REQUEST

Current Zoning: UC (uptown core)
Proposed Zoning: UMUD-O (uptown mixed-use development, optional)

Approximately 2.73 acres bound by the south side of South College Street, west side of East Martin Luther King Jr. Boulevard, north side of South Brevard Street, and east side of East Brooklyn Village Avenue.

The petition proposes to allow all uses permitted by-right and under prescribed conditions in the UMUD zoning district on a parcel currently developed with office uses.

TECHNICAL DATA SHEET

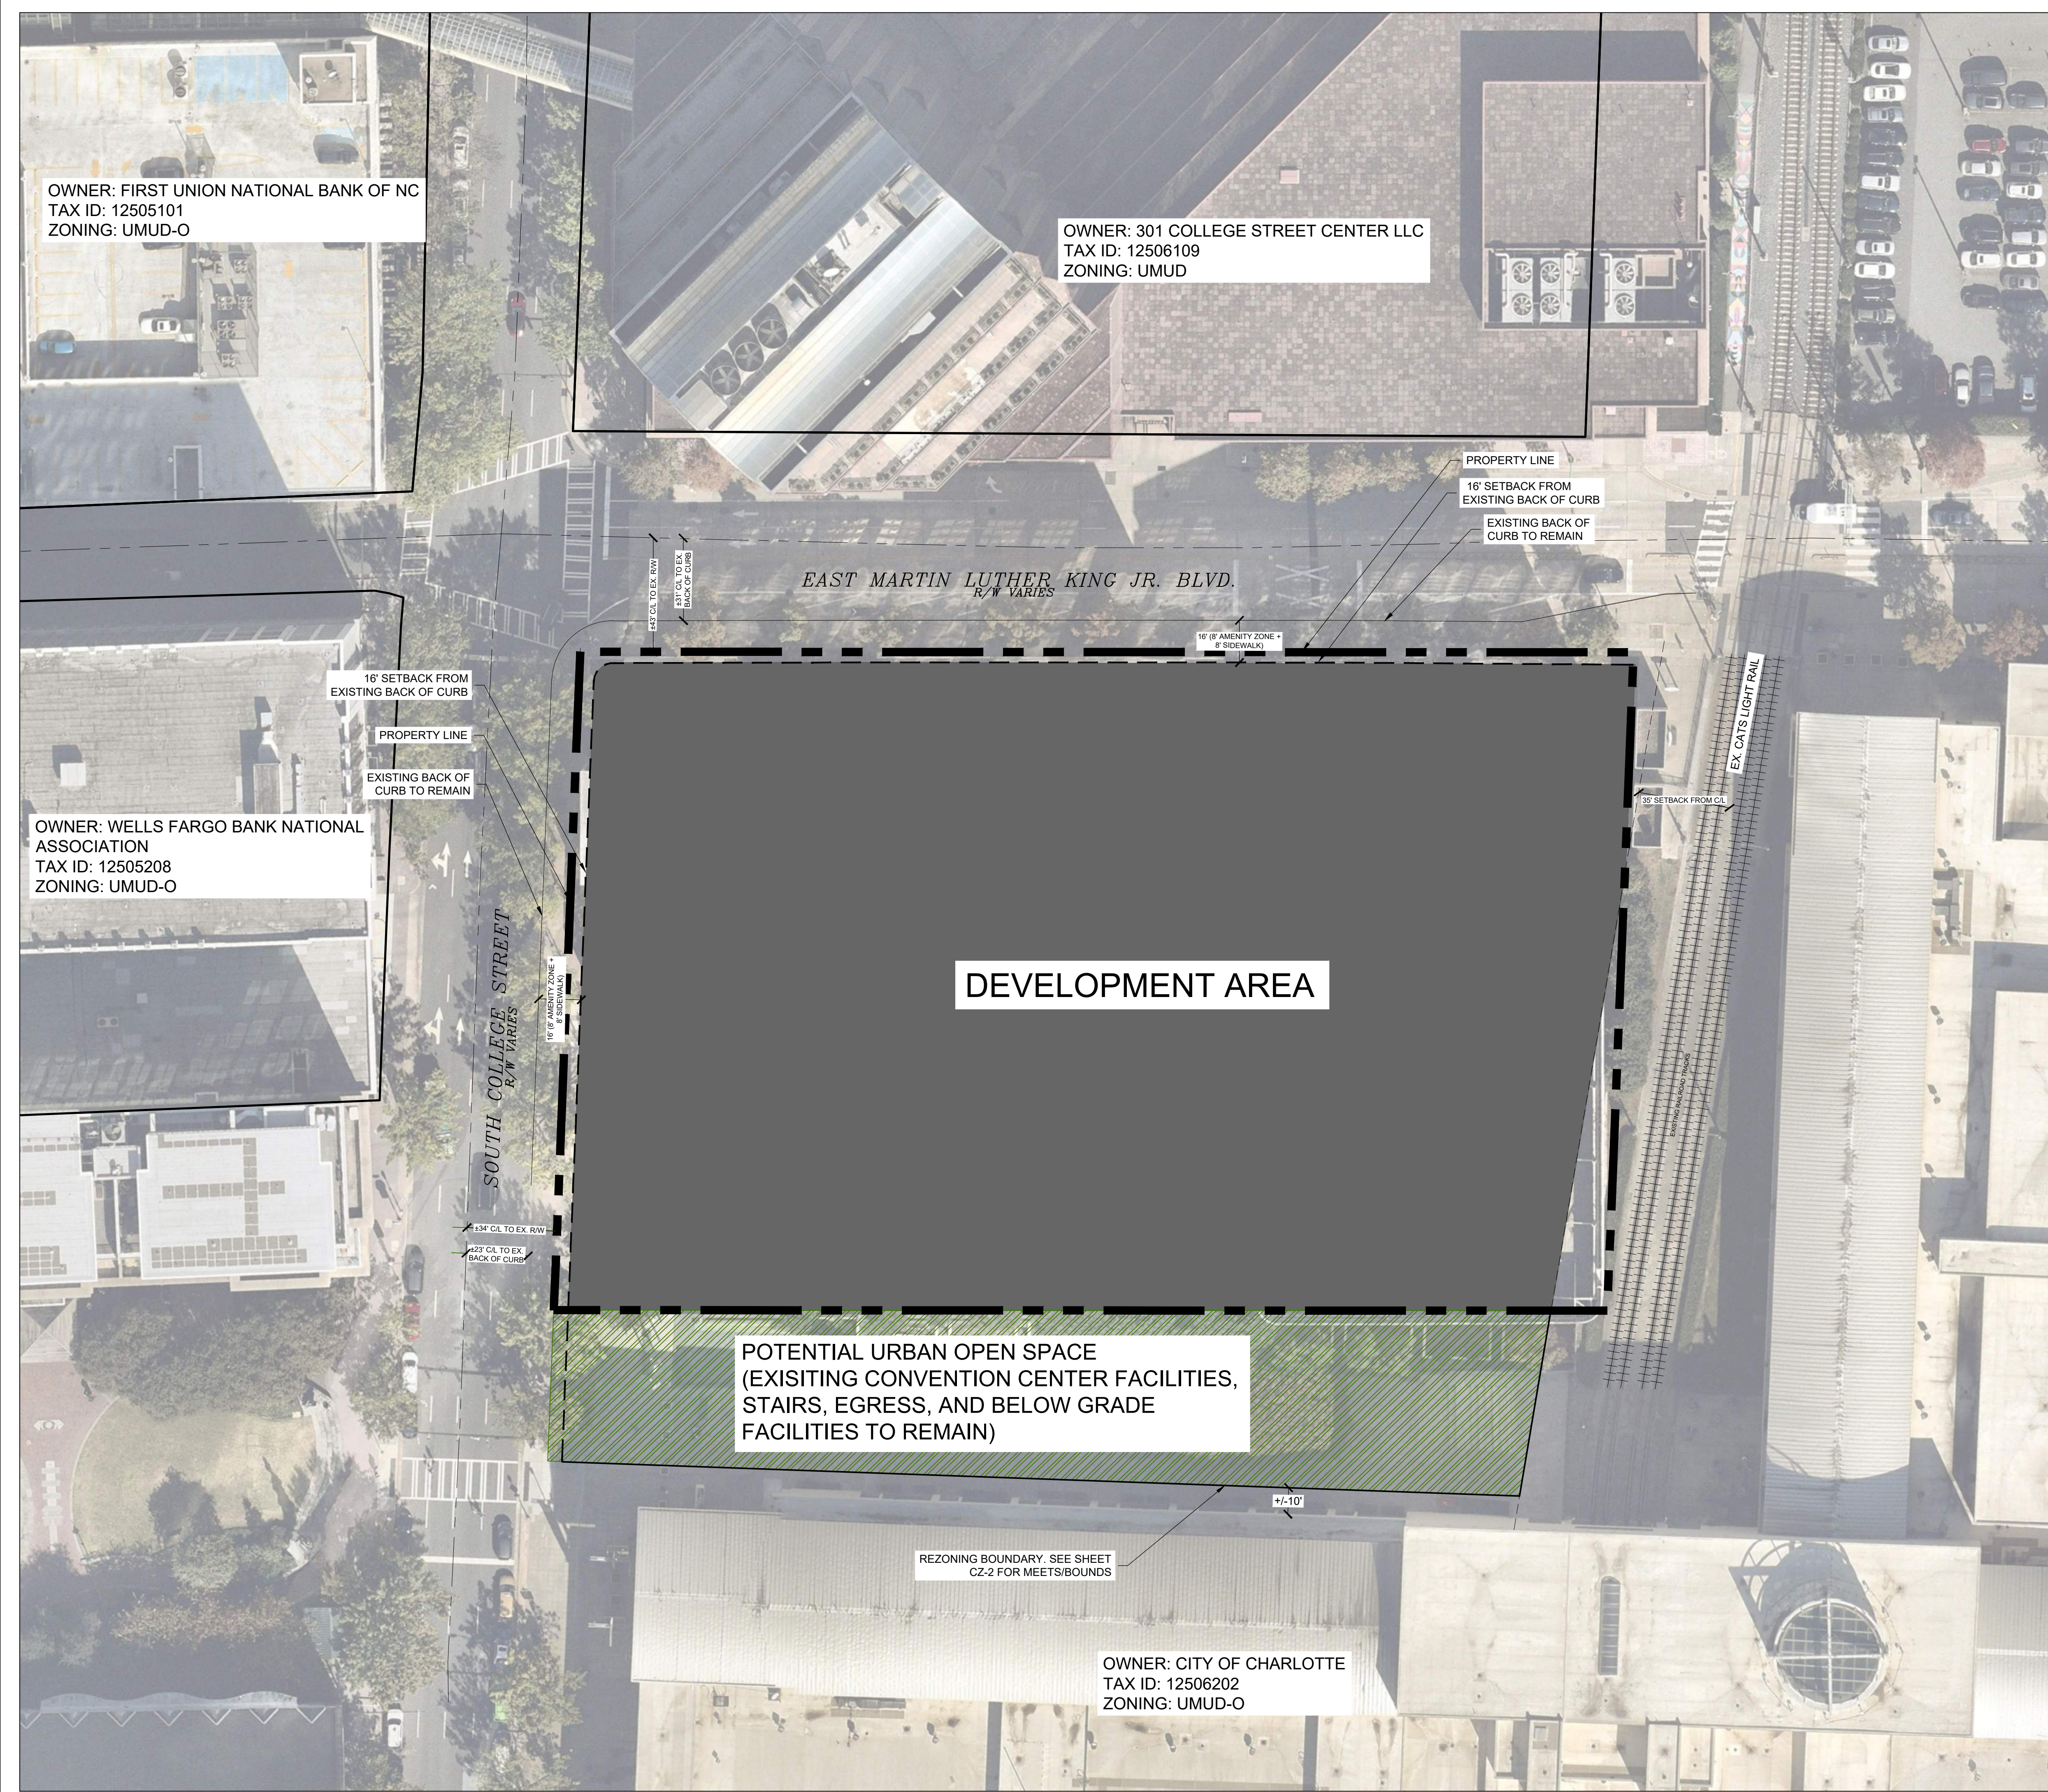
1. Commit to reserve space for a future bus stop within the pedestrian amenity zone on South College Street.
2. Commit to specific uses so that CDOT may determine if a TIS is needed.
3. Revised site plan and conditional notes to commit to 40' of ROW from the road centerline on South College Street. Label and dimension the ROW from the road centerline for all frontages.
4. Add a conditional note specifying, "A Right-of-Way Encroachment Agreement is required for the installation of any non-standard item(s) (irrigation systems, decorative concrete pavement, brick pavers, etc.) within a proposed/existing City-maintained street right-of-way by a private individual,

5. Label site access location points and types.
6. Add a conditional note specifying, "the Petitioner shall dedicate and convey in fee simple all rights-of-way to the City before the site's first building certificate of occupancy is issued. CDOT requests rights-of-way set at 2' behind back of sidewalk where feasible."
7. Add a conditional note specifying, "All transportation improvements will be approved and constructed before the site's first building certificate of occupancy is issued. The petitioner may phase transportation improvements if said improvements and phasing are explicitly described in site plan notes."
8. Remove site plan callout and other references stating that the existing convention center facilities along the Rail Trail corridor will be relocated by others.

9. Show proposed locations of valet parking on the site plan.

10. Clarify in the conditional notes what portion of the rail trail the petitioner will construct and what pedestrian improvements will be incorporated.
-
